From: Fiona Fitzgerald <Fiona.Fitzgerald@arun.gov.uk>
Sent: 22 July 2026 09:48
To: Planning.Responses <Planning.Responses@arun.gov.uk>
Cc: Hebe Smith <Hebe.Smith@arun.gov.uk>
Subject: WA/45/26/PL

Environmental Health has **no objection** in principle to this application.

Proposed Plans and Elevations

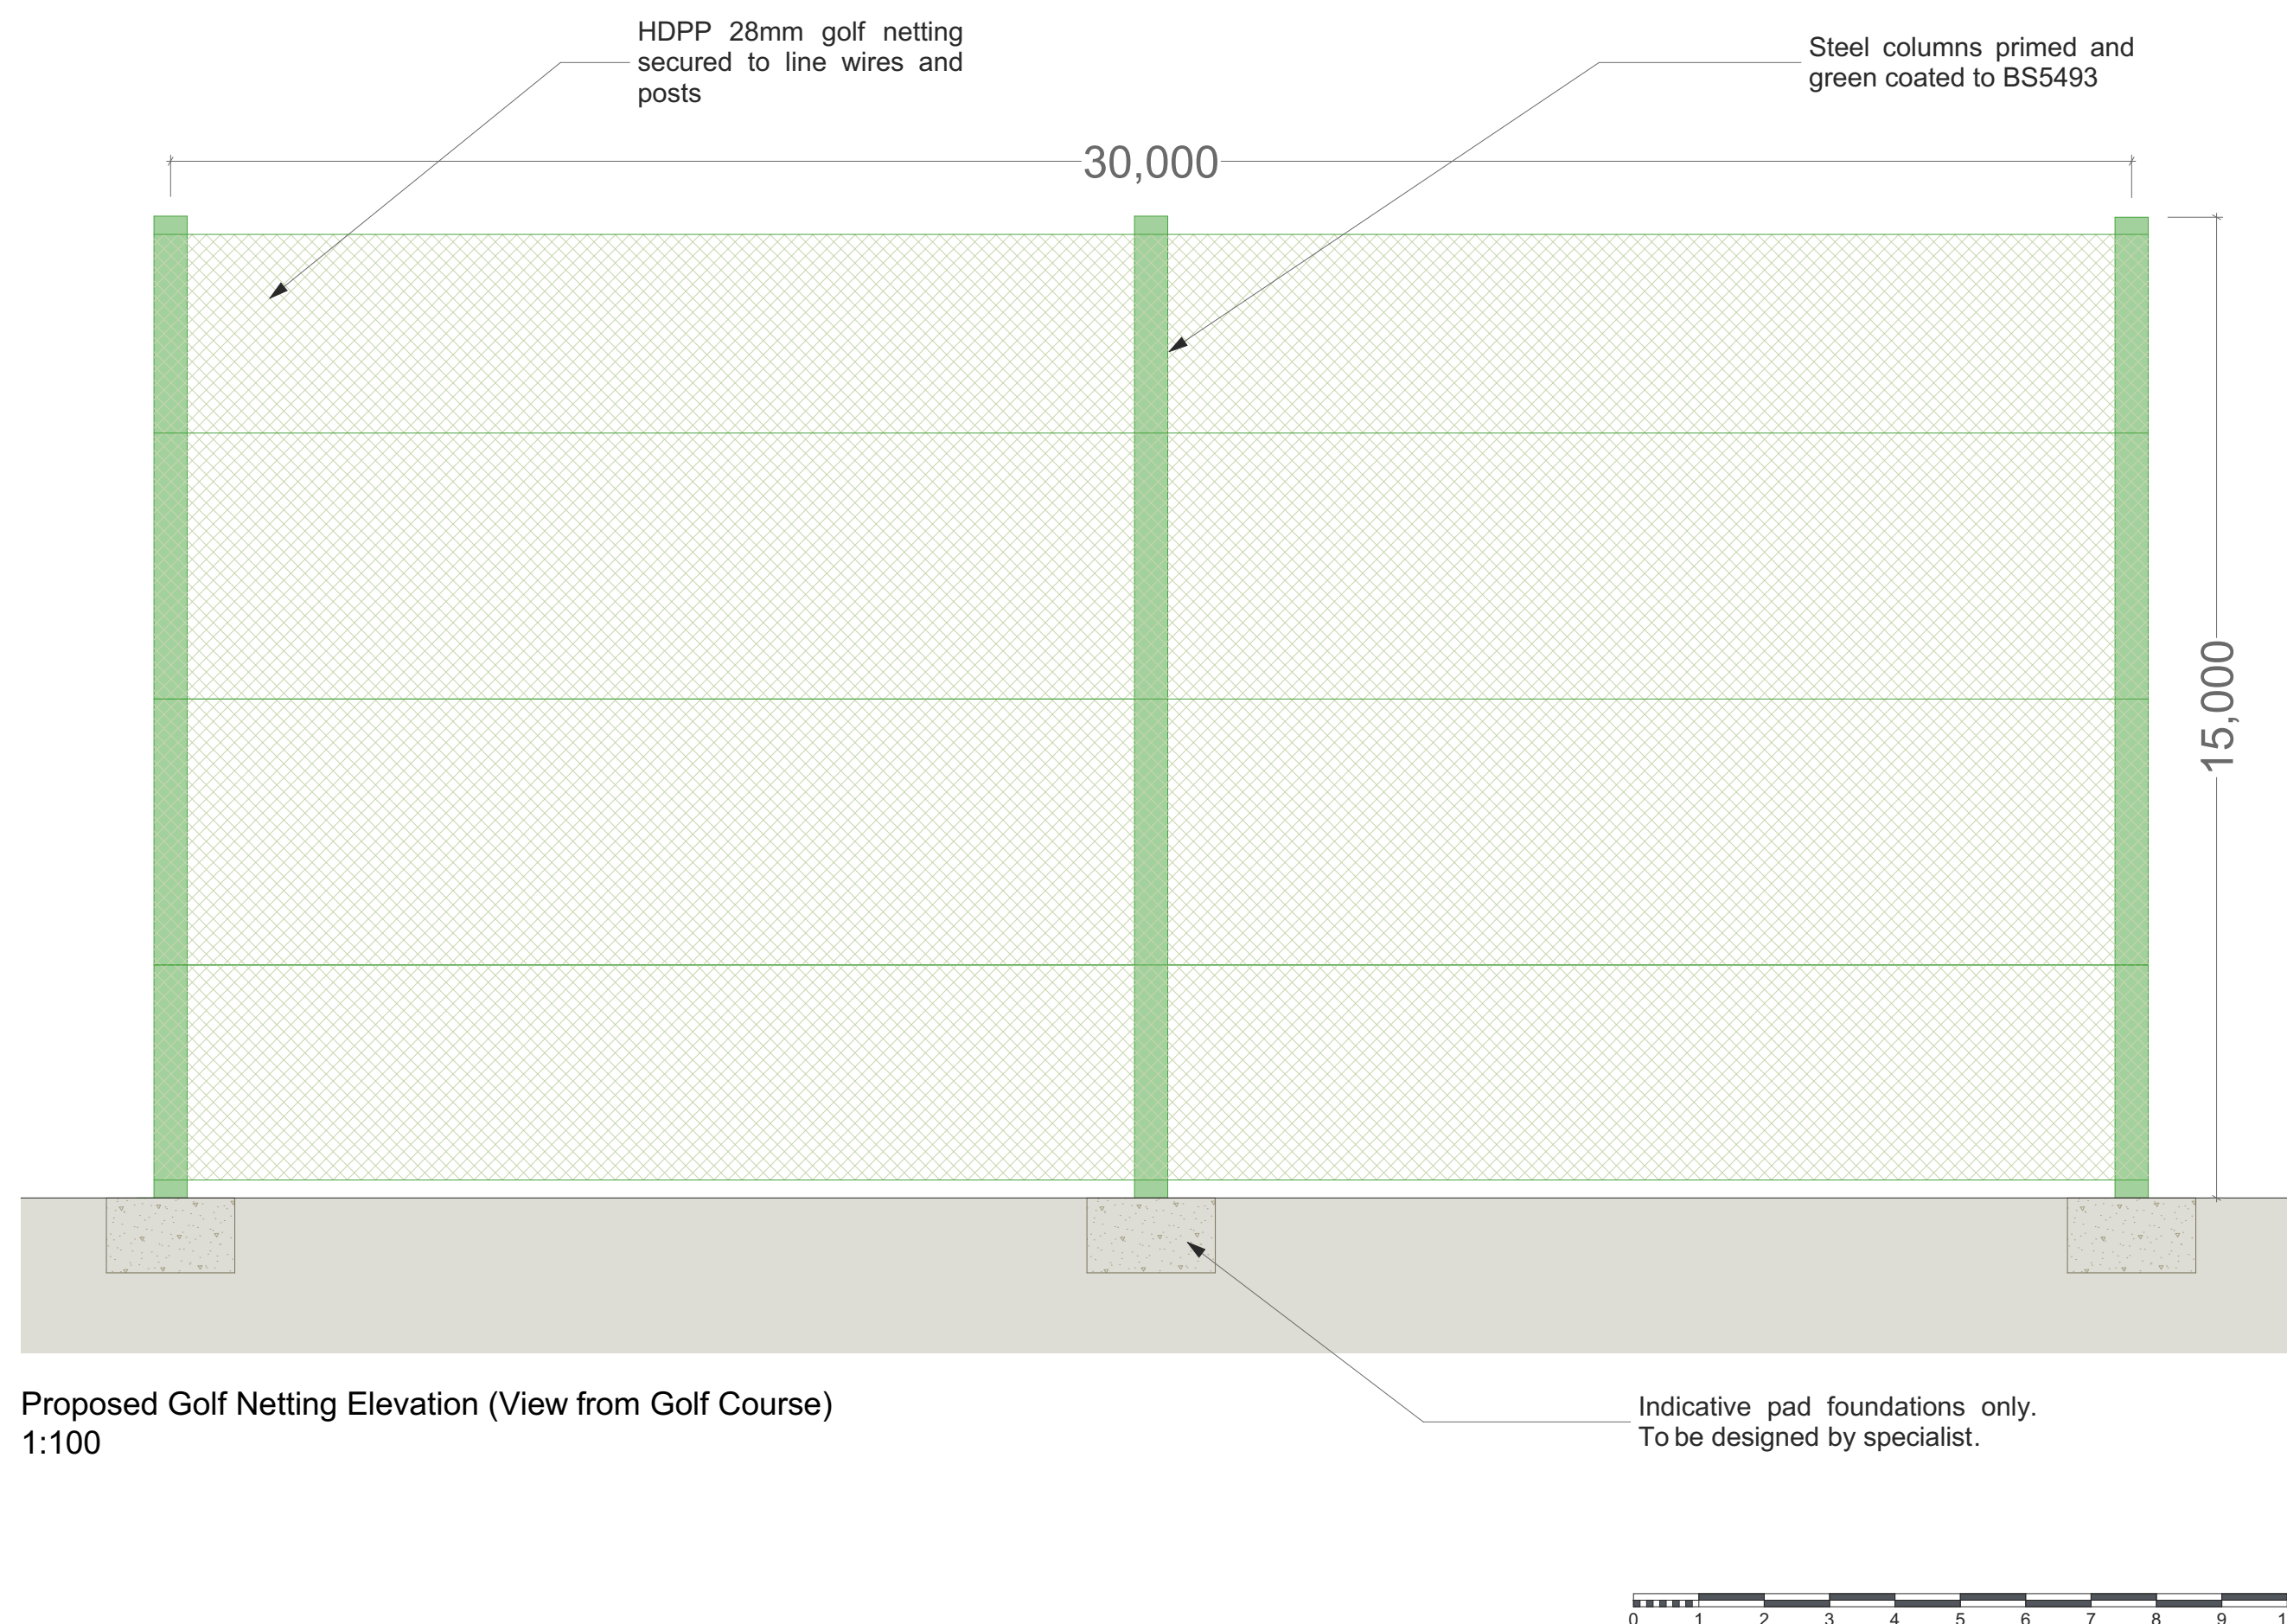
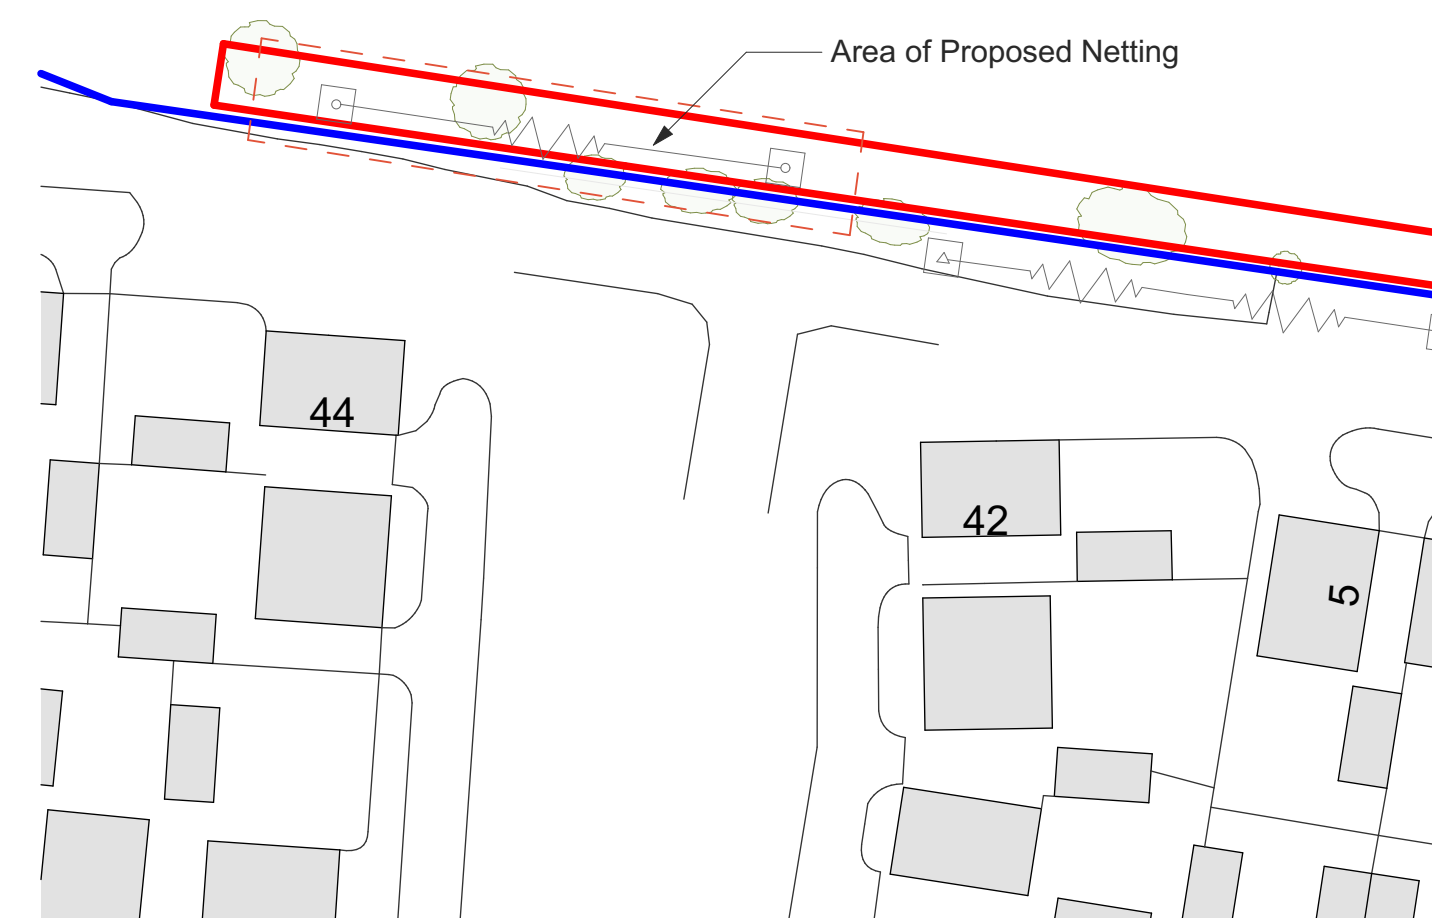
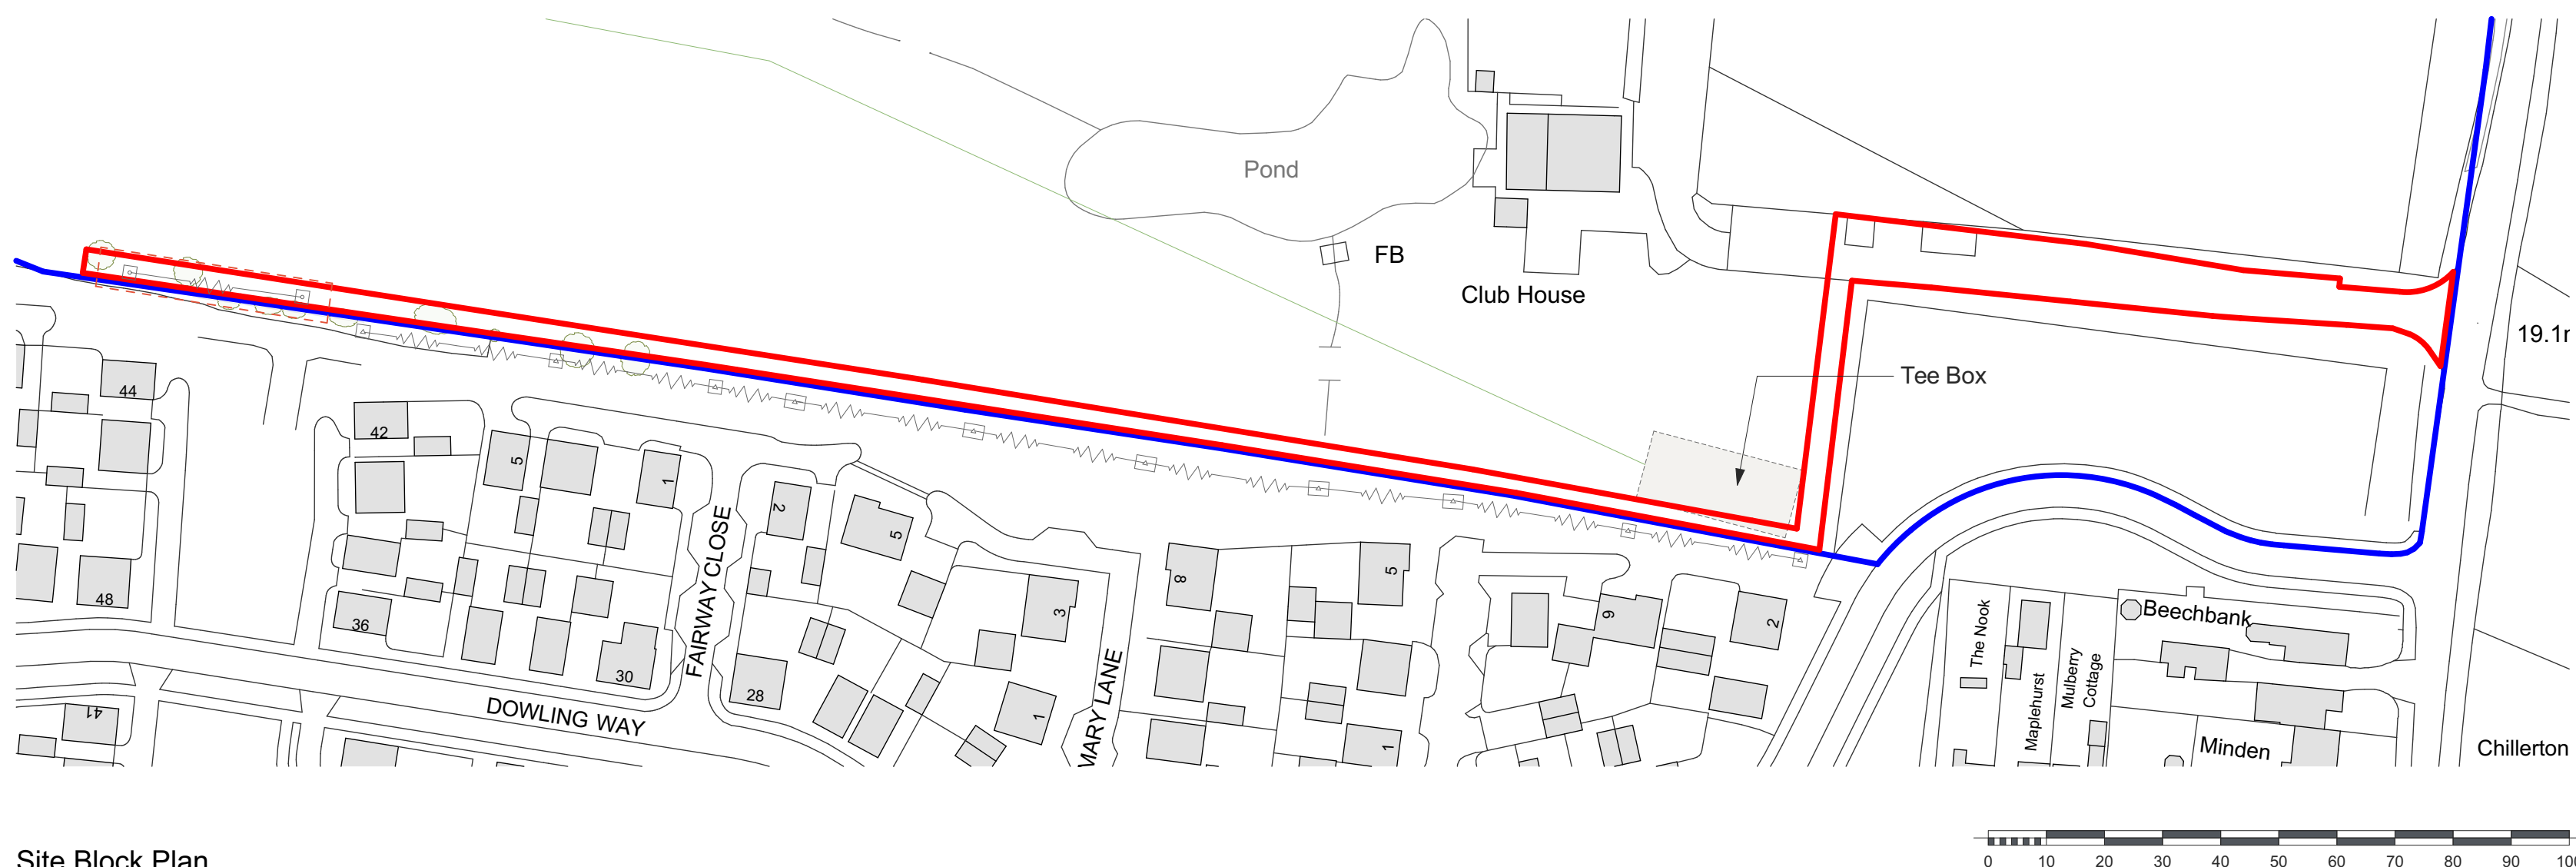
However, this Department considers that insufficient information has been provided to ensure that the extent of the proposed golf netting is sufficient to resolve the issue of escaping golf balls.

Please could the applicant provide a detailed assessment by a suitably qualified person confirming that the extent of the proposed netting is sufficient.
